DECISION DELEGATED TO HEAD OF PLANNING

Application No: H11-1264-25 **Applicant:** Tears of Sutton Bridge Ltd

Proposal: Re-location of 24 Hour vehicle recovery, haulage, parking & storage

Location: Land To The Side & Rear Of 90 Bridge Road Long Sutton Spalding

SITE PLAN - PROPOSED 1:250

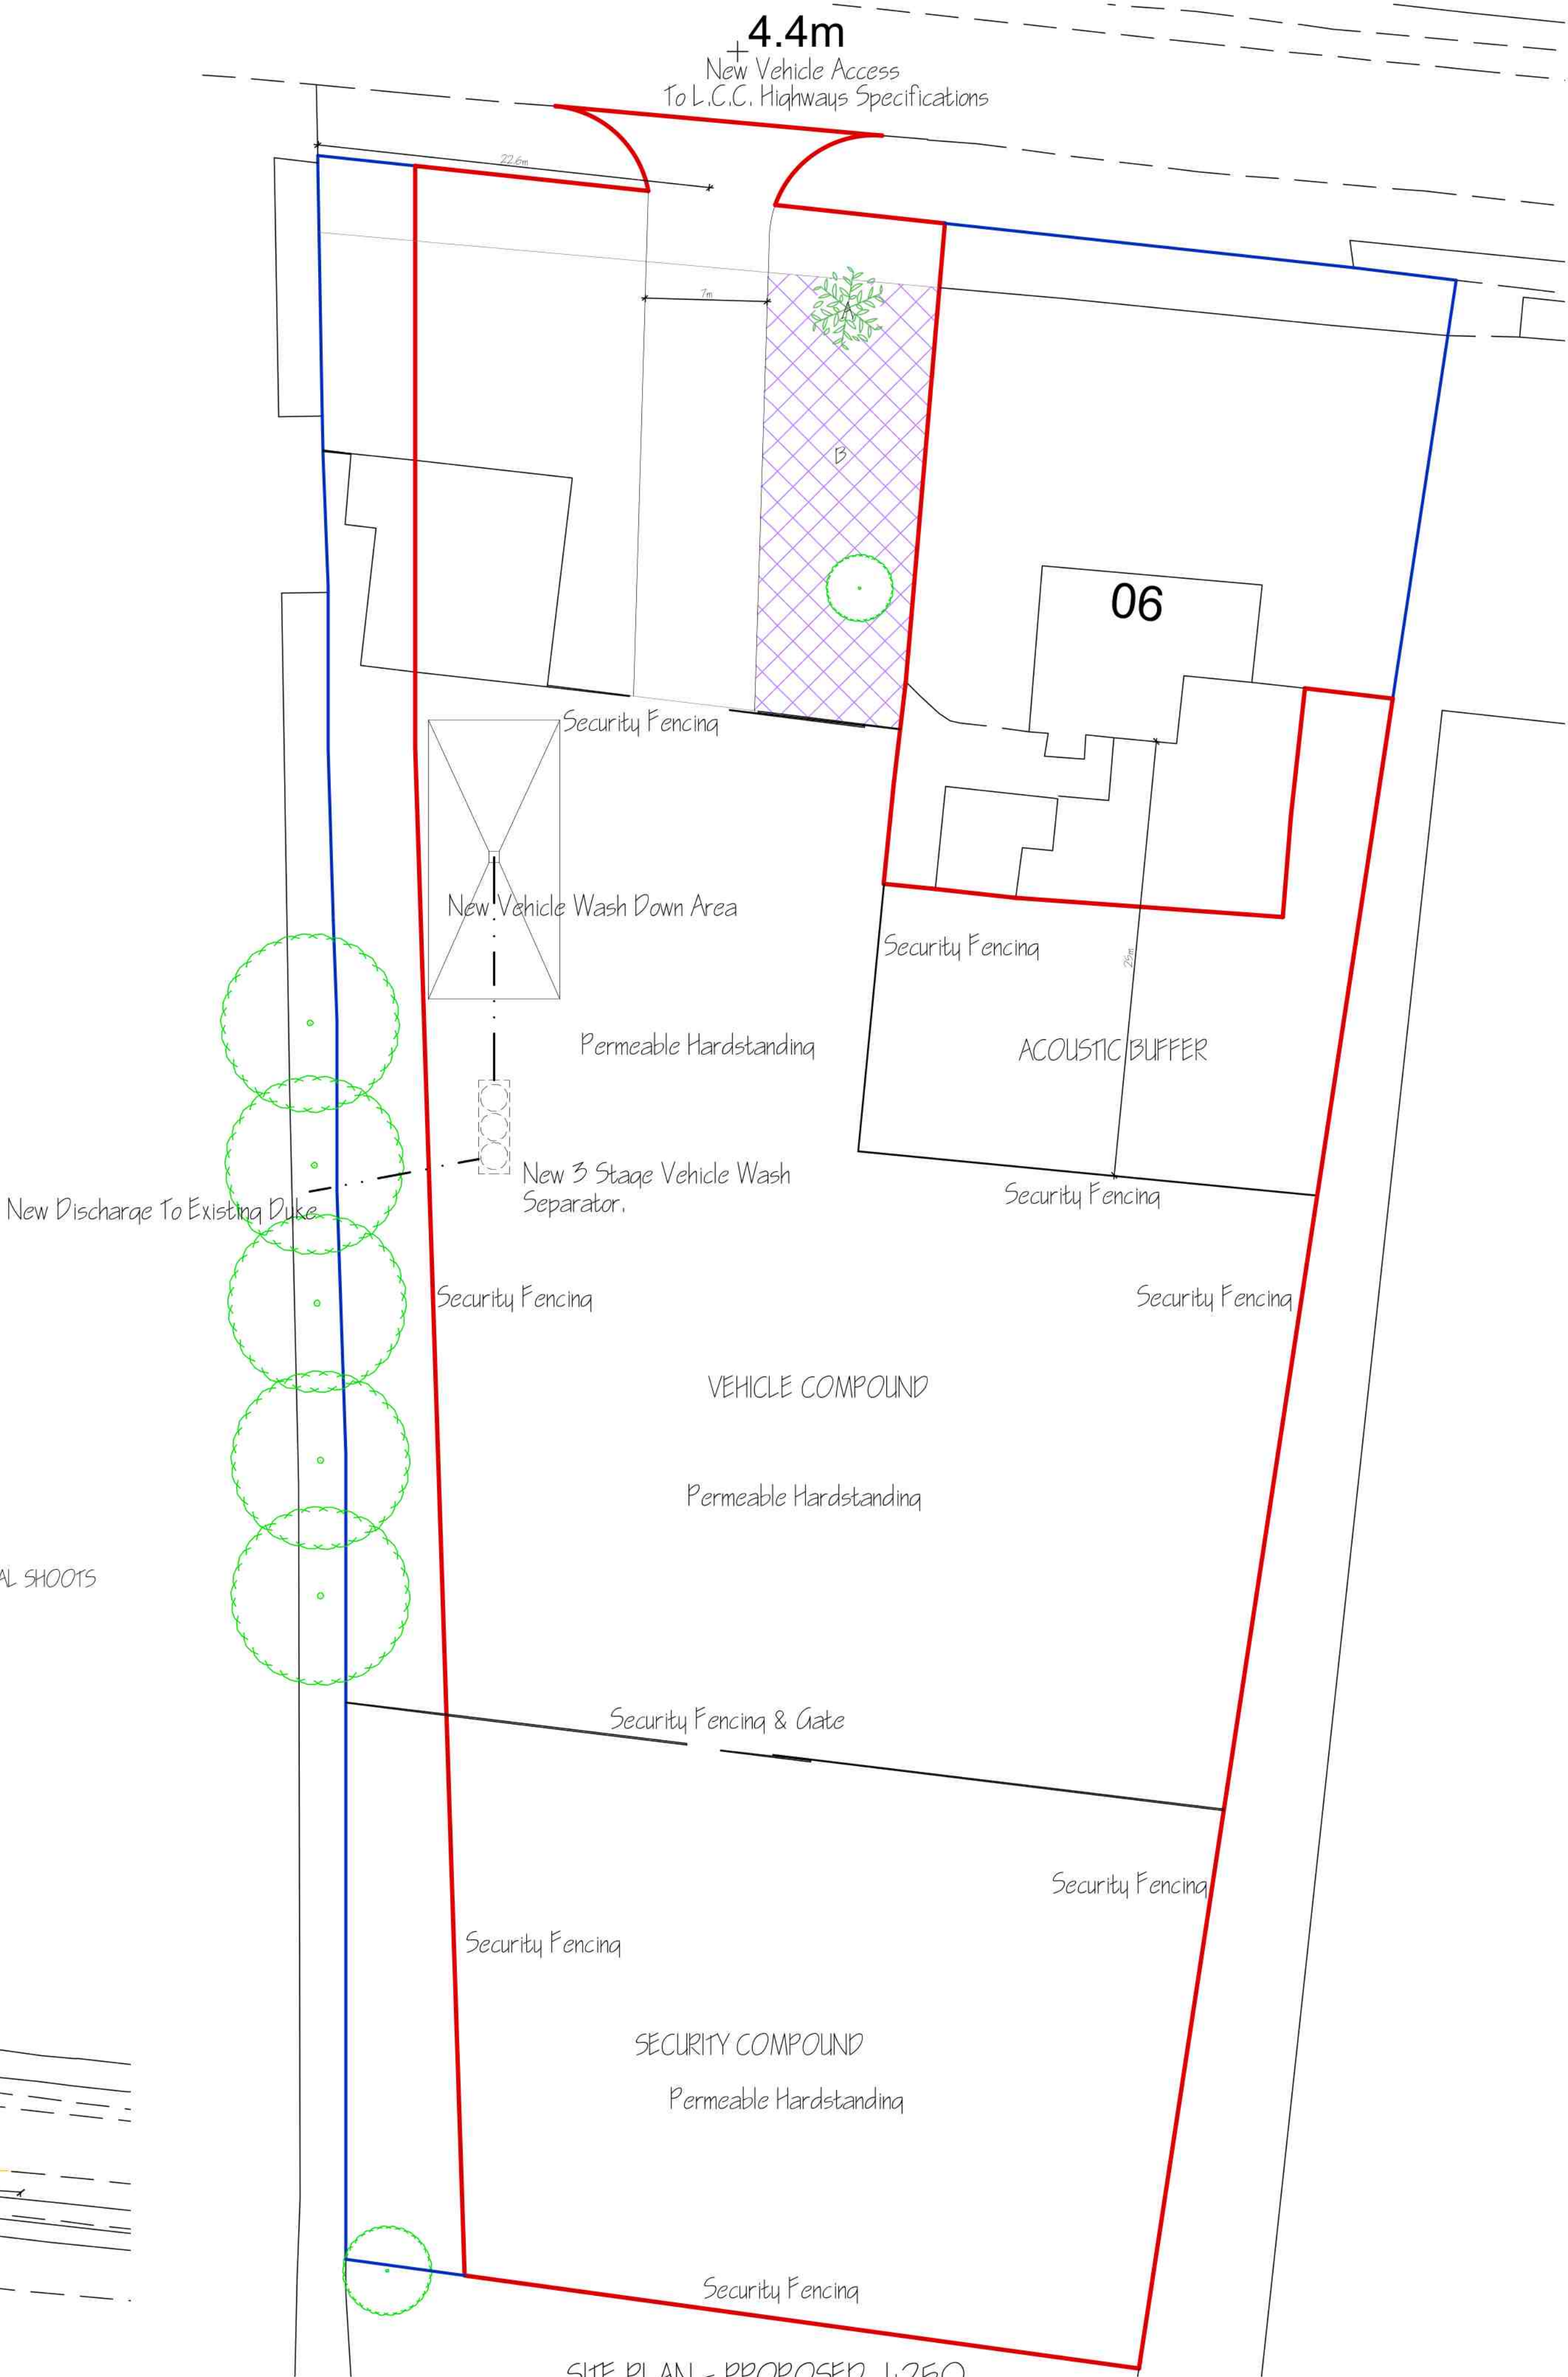
From the details submitted to support the planning application (4431-25 OIF SITE PLAN) the proposed method of surface water management does not relate to Anglian Water operated assets. As such, we are unable to provide comments on the suitability of the surface water management.
